**NELSON GEOTECHNICAL
ASSOCIATES, INC.**

MEMORANDUM

RE: Intrachat Hoang Residence
7929 East Mercer Way
Mercer Island, Washington
NGA File No. 1276521

This memorandum presents our responses to the geotechnical peer review performed by the City of Mercer Island regarding the proposed residence development located at **7929 East Mercer Way on Mercer Island, Washington.**

FOUNDATION / BASEMENT PLAN
SCALE: 1/4" = 1'-0"

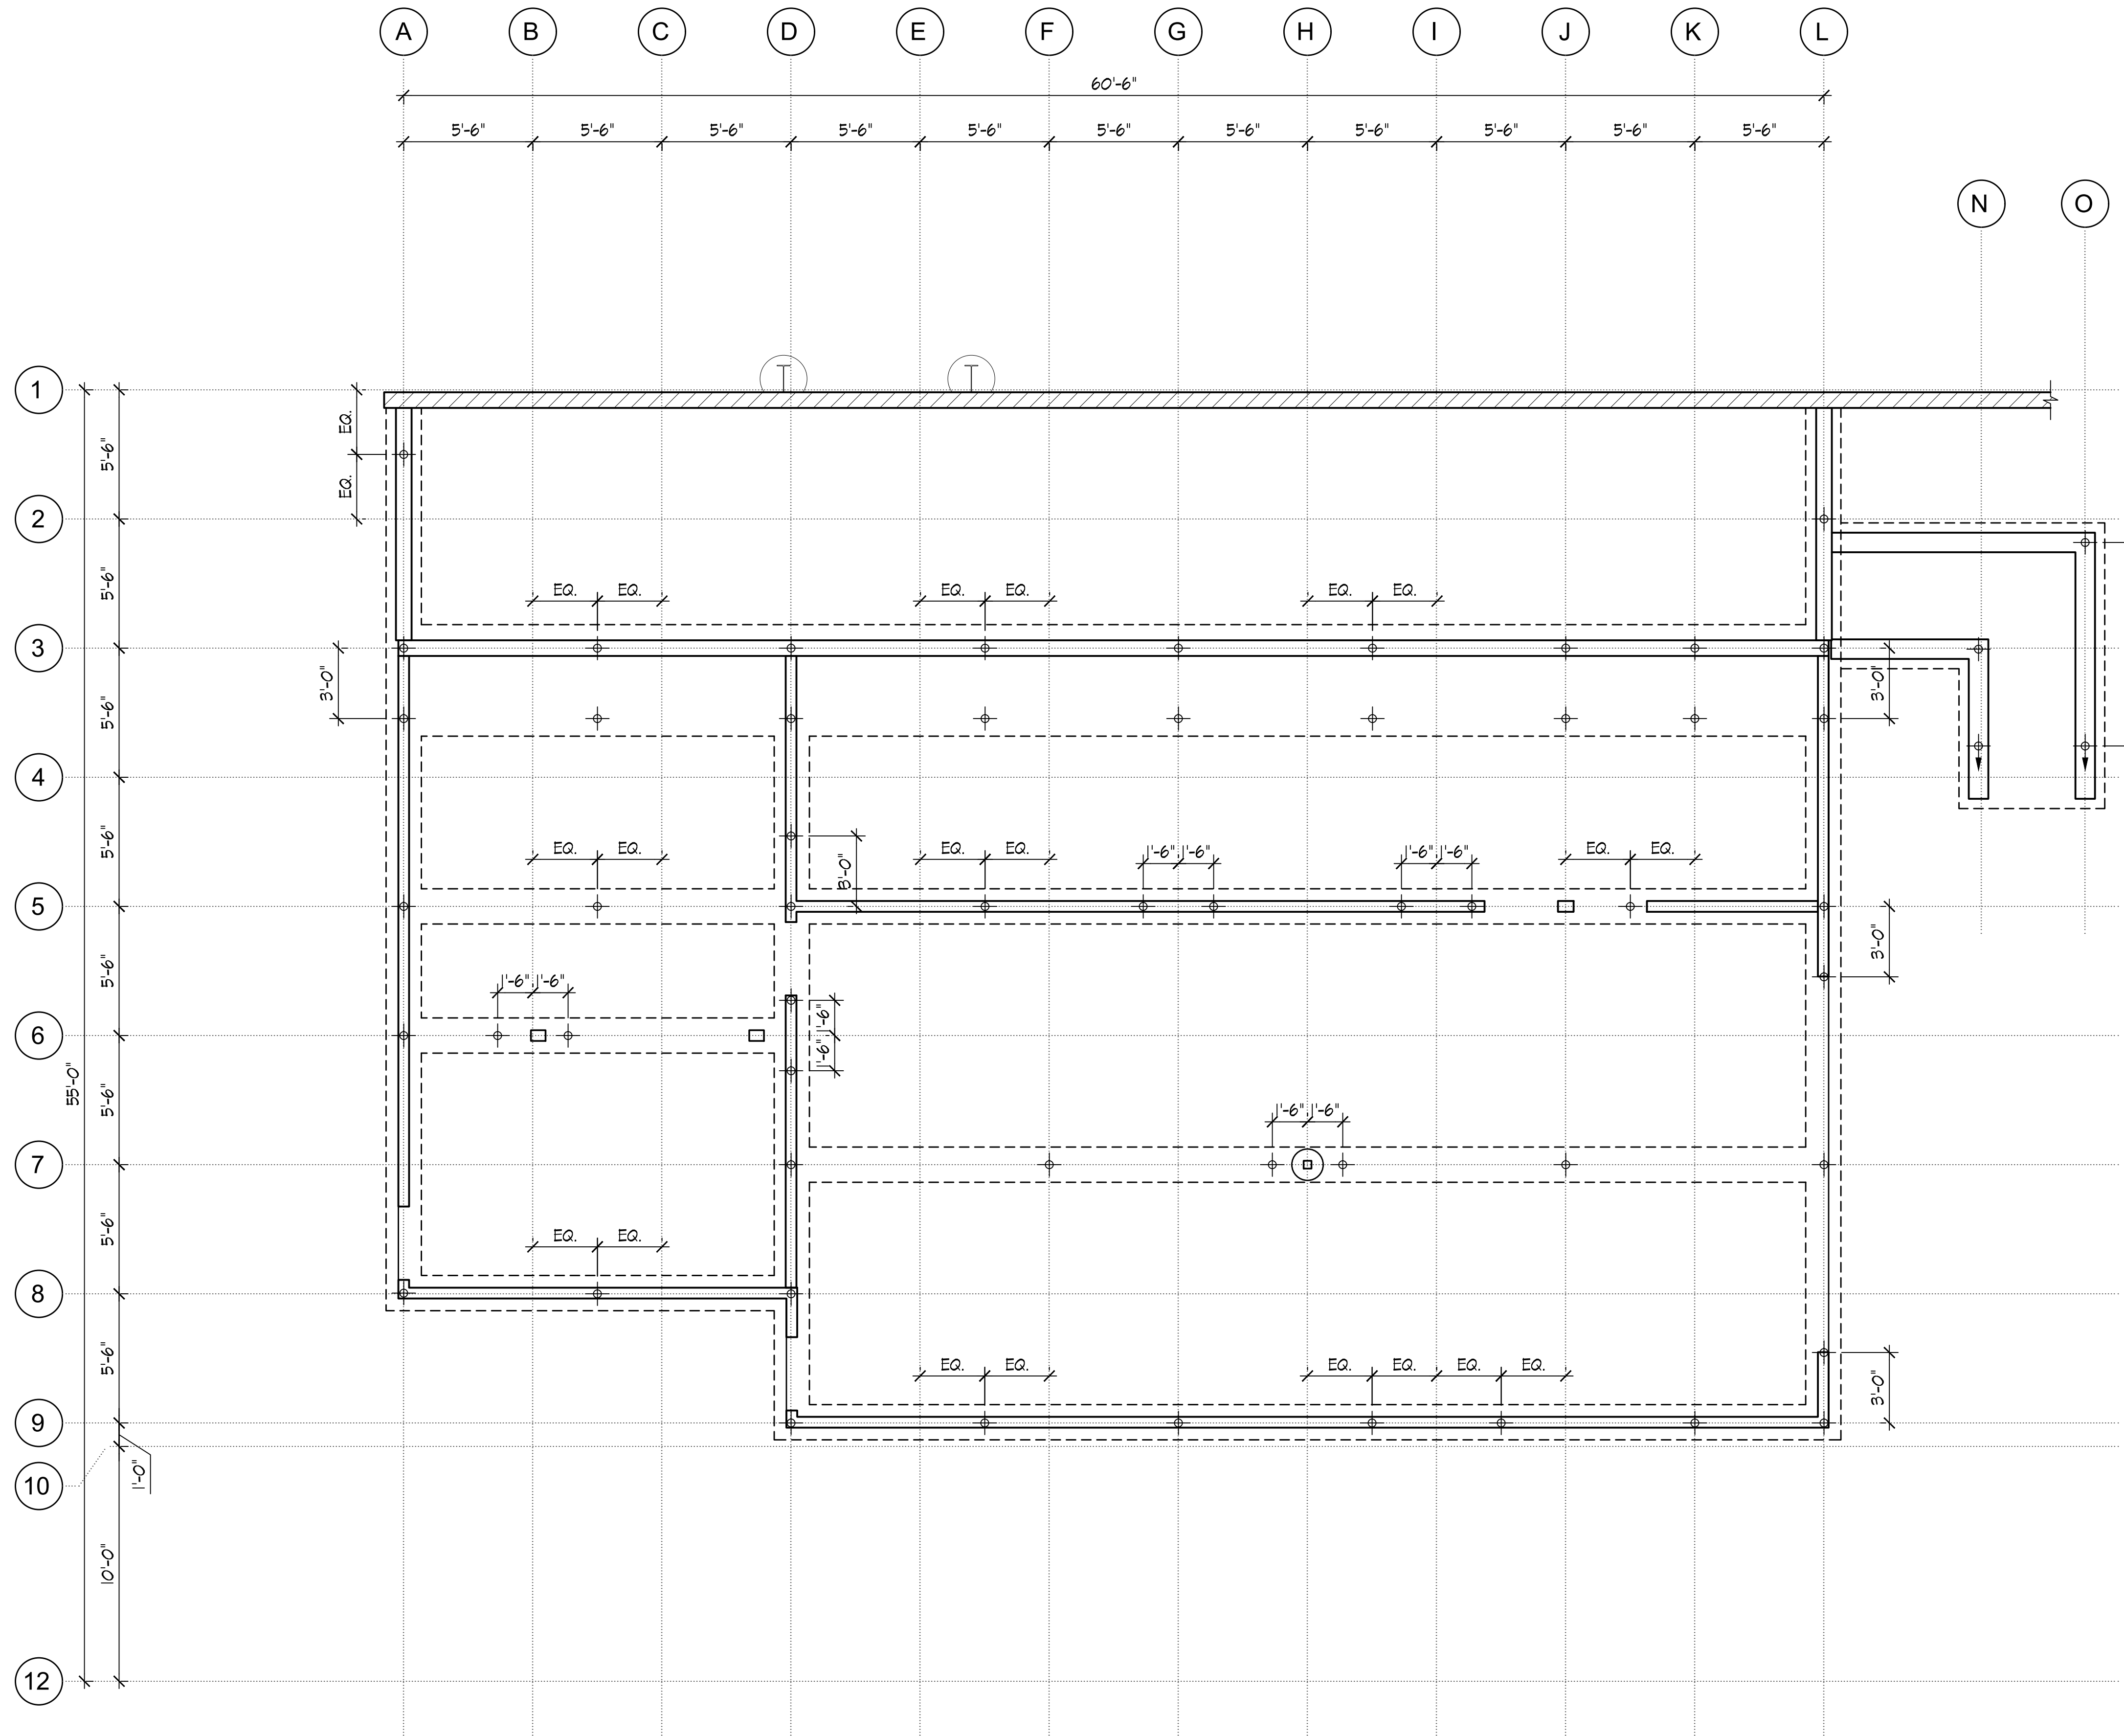
Comment 4: *The geotechnical engineering explorations do not appear to locate the bearing layer for the proposed piles. Provide additional subsurface information to support proposed design and to be able to address the liquefaction concerns and potential post-liquefaction deformations discussed in a previous comment.*

Response 4: As discussed briefly in **Response 1**, we have reviewed boring logs performed by others in the near vicinity to the site. The nearest geotechnical boring log documented approximately 5-feet of undocumented fill underlain by 3-feet of loose, saturated sandy gravel, which we interpreted to correlate to the same colluvial sand layer encountered in B-2 performed at the subject site. Additionally, the surface elevation of the above-referenced boring is approximately at the termination elevation of B-2. Underlying the sandy gravel, the nearby boring encountered slightly disturbed to massive, silt; stiff to hard, which we interpreted as glacial lacustrine deposits, typical of this area. Other borings further downslope and southeast of the property also indicate silt deposits to the depths explored. Based on the review of nearby soil data, we anticipate the fine-grained strata discussed above lies within approximately 5- to 10-feet of the termination depth of lower elevation B-2 performed at the site. Furthermore, in our opinion, the consistency and relative soil density of the lower silt deposit should support the provided design foundation loads for the proposed structure and the additional overall thickness of liquefiable sandy soil that is interpreted to underly the B-2 boring has been accounted for in the liquefaction modeling as discussed in **Response 1**. That said, we expect the pin piles proposed for this site should advance 40- to 50-feet below the existing ground surface to reach non-liquefiable and cohesive soil, suitable for deep foundation support.

TIEBACK TO PILE CONNECTION 10

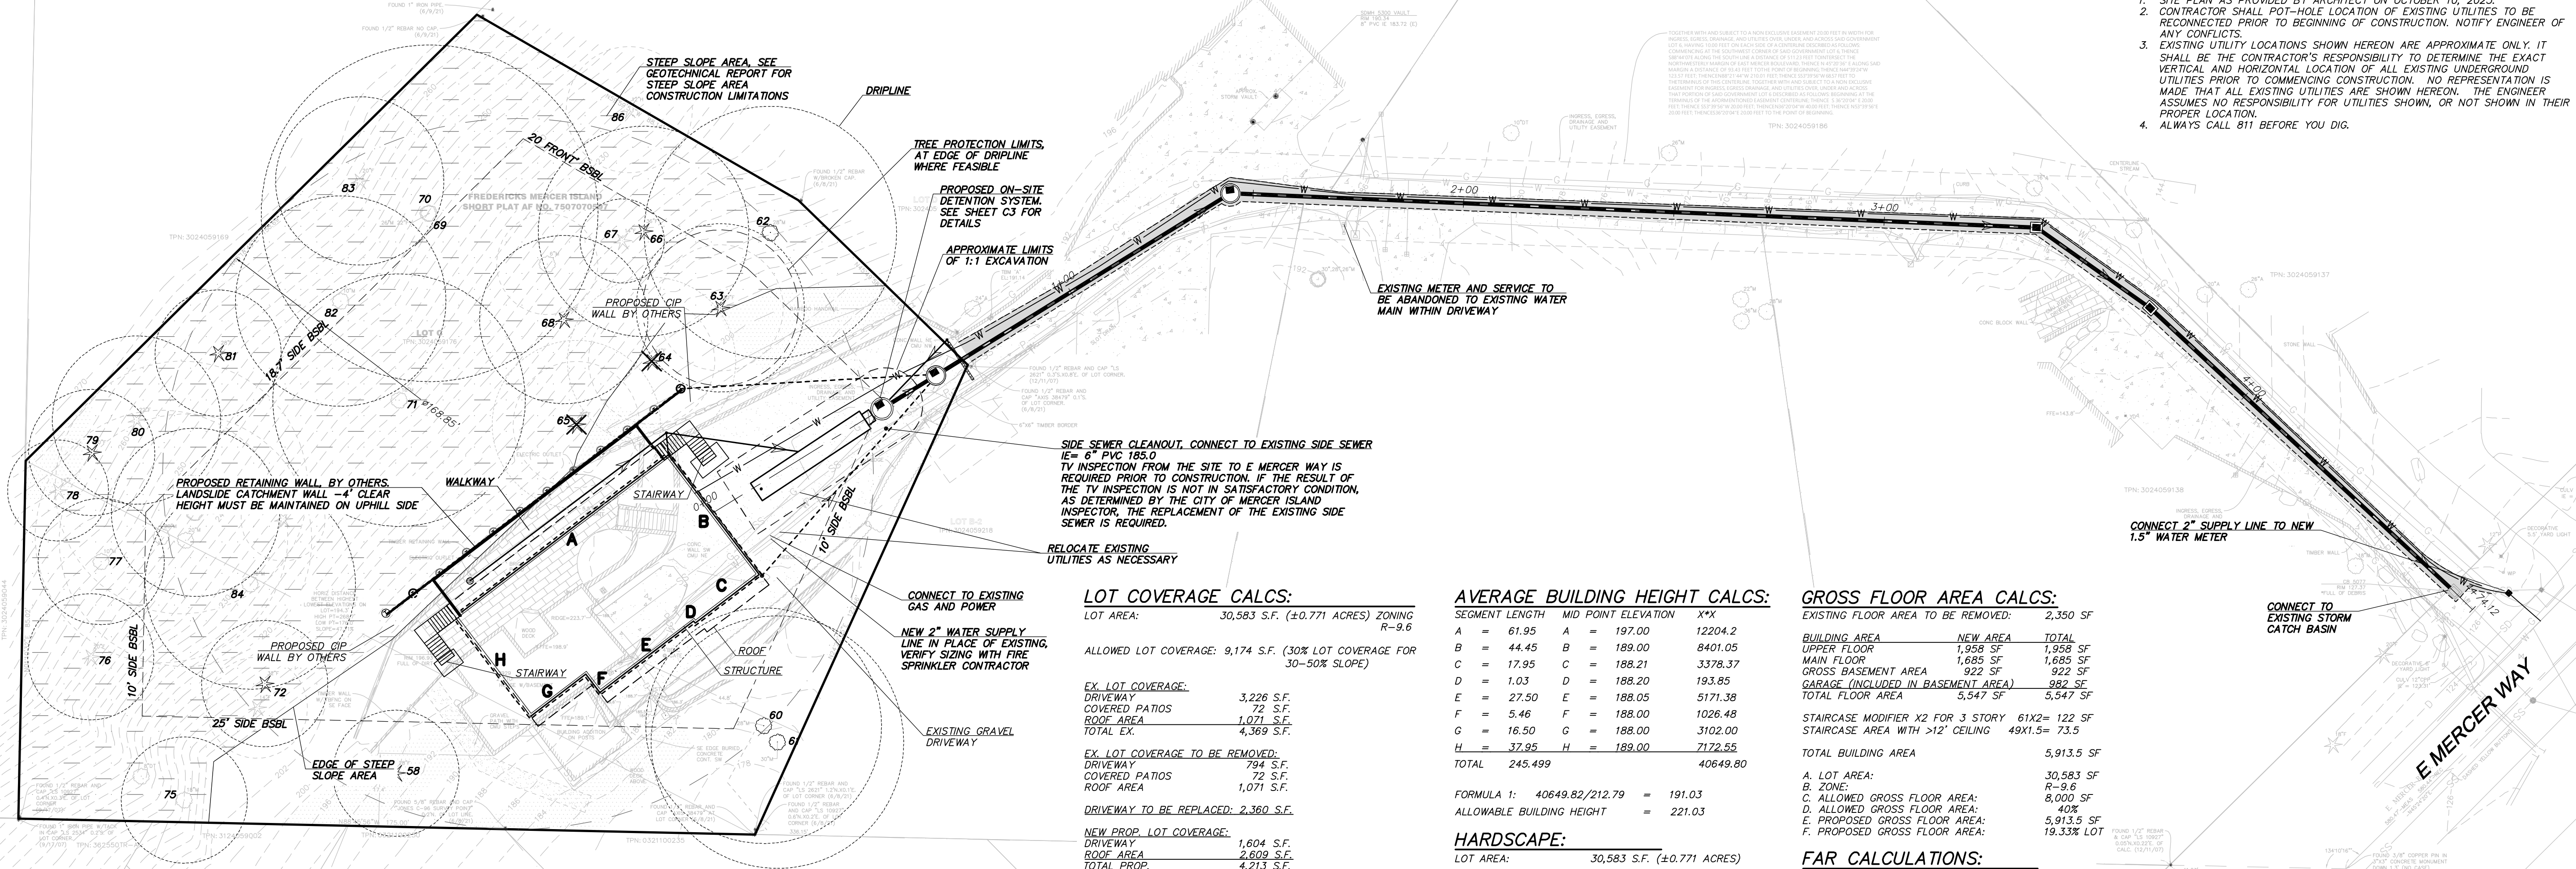
Comment 6: *The excavation required for the detention tank in this area will reduce the passive resistance from the current design value. Geotechnical engineer to provide a recommended reduced passive resistance to account for the detention tank excavation located in front of a portion of the shoring wall. Provide recommendations in a report addendum. Revise shoring wall design accordingly using the reduced passive pressure in the area of the detention tank excavation.*

Response 6: The location of the detention tank and shoring wall design were revised and based on the new layout, we do not anticipate reductions in passive resistance for the shoring system.
